Response to Planning Application

From: Arun District Council Greenspace

Application ref: AL/46/20/PL

Description: Demolition of Wings House & the erection of 81 No. replacement dwellings (80 net new dwellings), access arrangements, sustainable drainage measures, public open space, landscaping & all other associated works. This application is a Departure from the Development Plan.

9 LAYOUT - SITE PLAN

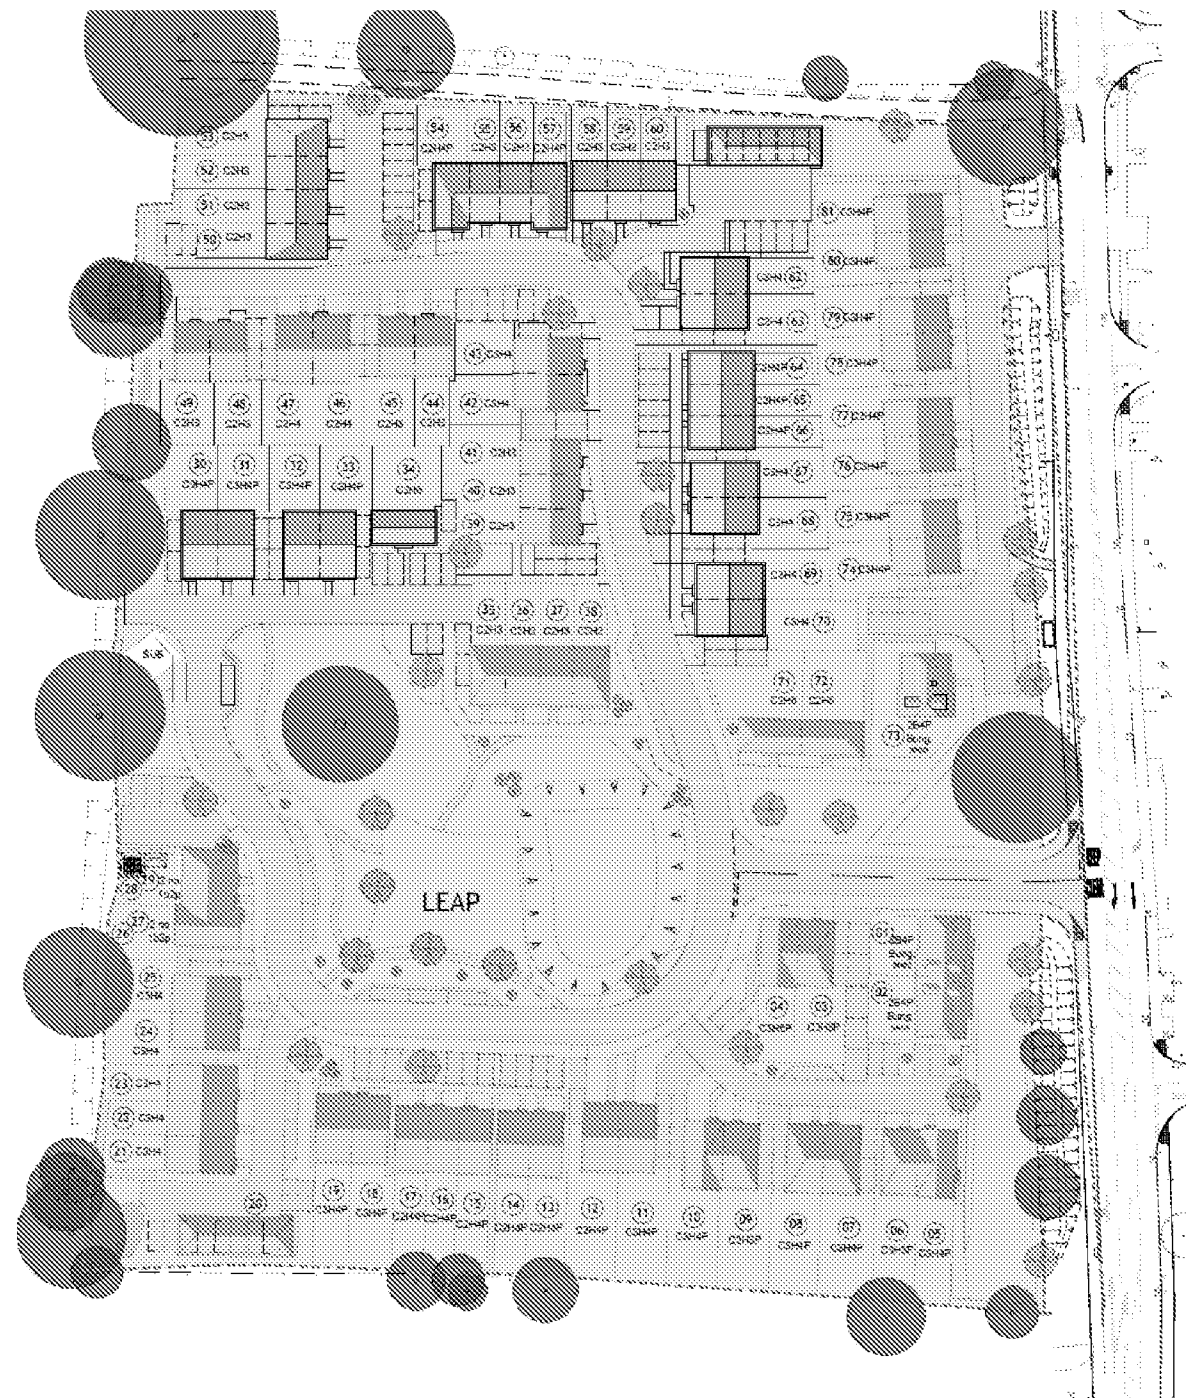
This is a CIL liable development. The indicative layout has shown 81 dwellings (80 net new dwellings), within the proposals with an area of POS, located centrally to the development and buffer planting to perimeter, largely to accommodate existing trees. Consideration appears to have been given to positioning dwellings facing onto POS areas in line with good design principles, which is good to see.

A development of this size will require the provision of onsite POS minimum area of 5,702m² plus the provision of onsite, unequipped natural play LAP to include such features as landform, boulders or logs, seat and litter bin and onsite equipped LEAP 980m². Confirmation of the area of POS being proposed would be required.

The indicative layout appears to show an area detailed as potential SuDS within the POS area. Should the need for SuDS be required with the development then these areas should not be included in the total area of usable POS calculations. Further detail would also be required regarding depths and indication of timeframe for water holding periods ie dry feature or water holding body. This would be particularly relevant because of the proximity in relation to play and dwelling boundaries.

Consideration of existing trees and hedges within the site would be required and any removals agreed with Arun District Councils Tree Officer. Existing vegetation to the perimeter of these proposals may conflict with private gardens and come under pressure to be removed or pruned. It is good to see that the indicated green buffer shown to the boundaries of this development would go some way to accommodate existing trees and allow for their retention.
